Subject: FW: Consultation on planning application 3/2012/0359 land adj Woodfold Park, Further Lane, Mellor

I have no objection to this proposal, subject to the following conditions:

Site Plan 1:1250

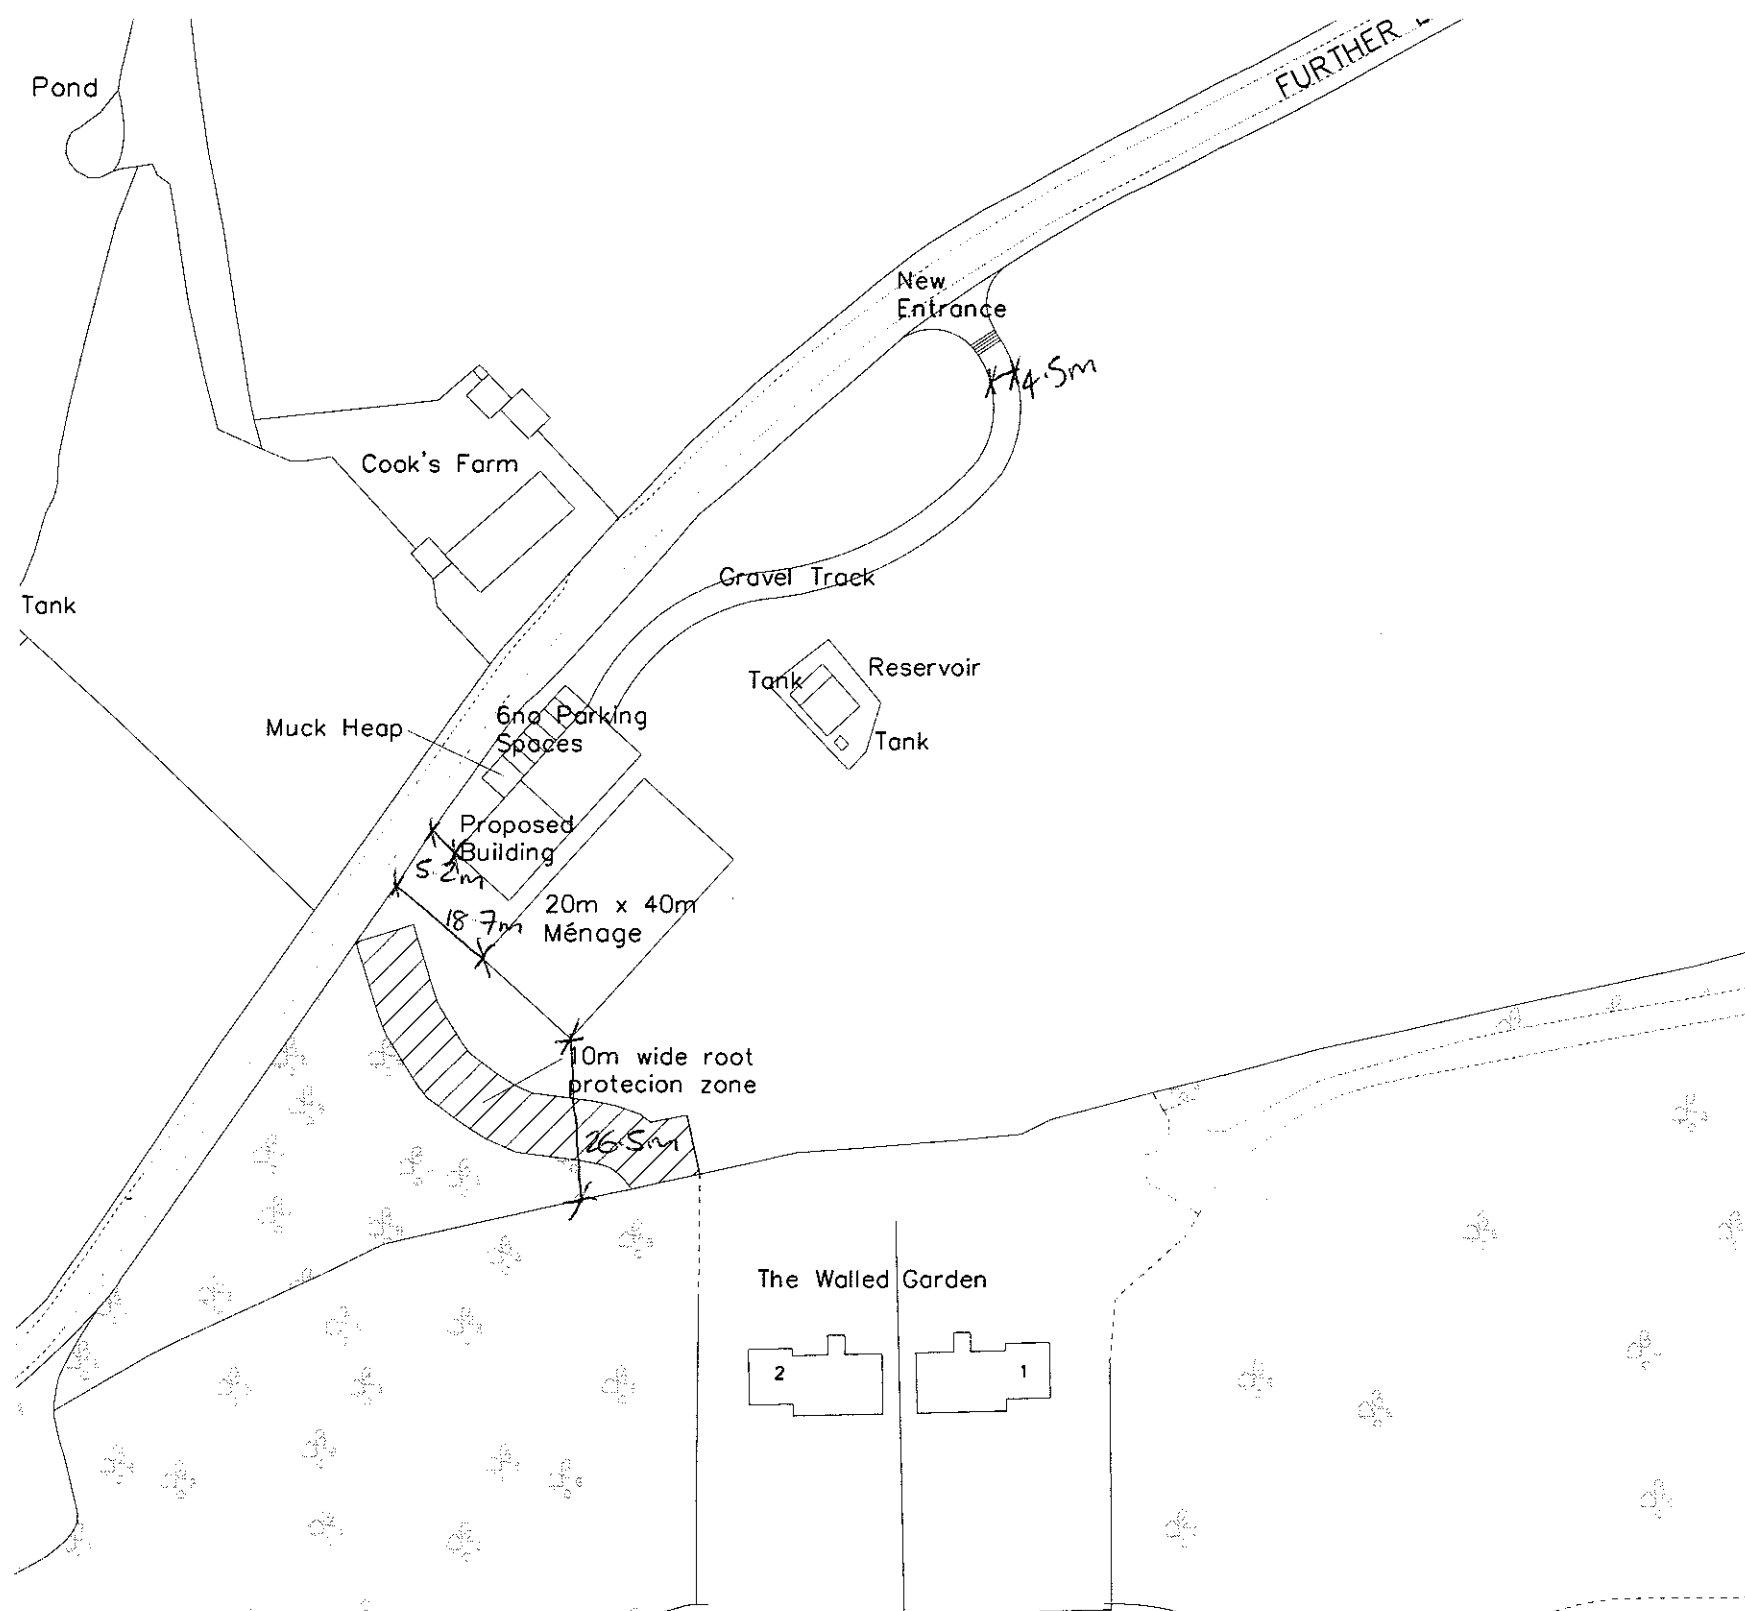
1. Before the proposed access is used for vehicular purposes, any gateposts erected at the access shall be positioned 5 metres behind the nearside edge of the carriageway of Further Lane. The gates shall open away from the highway. Reason: To permit vehicles to pull clear of the carriageway when entering the site.

2. Before the access is used for vehicular purposes, that part of the access extending from the highway boundary for a minimum distance of 5 metres into the site shall be appropriately paved in tarmacadam, concrete, block pavements, or other approved materials. Reason: To prevent loose surface material from being carried onto the public highway thus causing a potential source of danger to other road users.

3. The existing field access shall be physically and permanently closed and the verge and hedgerow shall be reinstated. Reason: To limit the number of access points to the highway at this location in the interests of road safety.
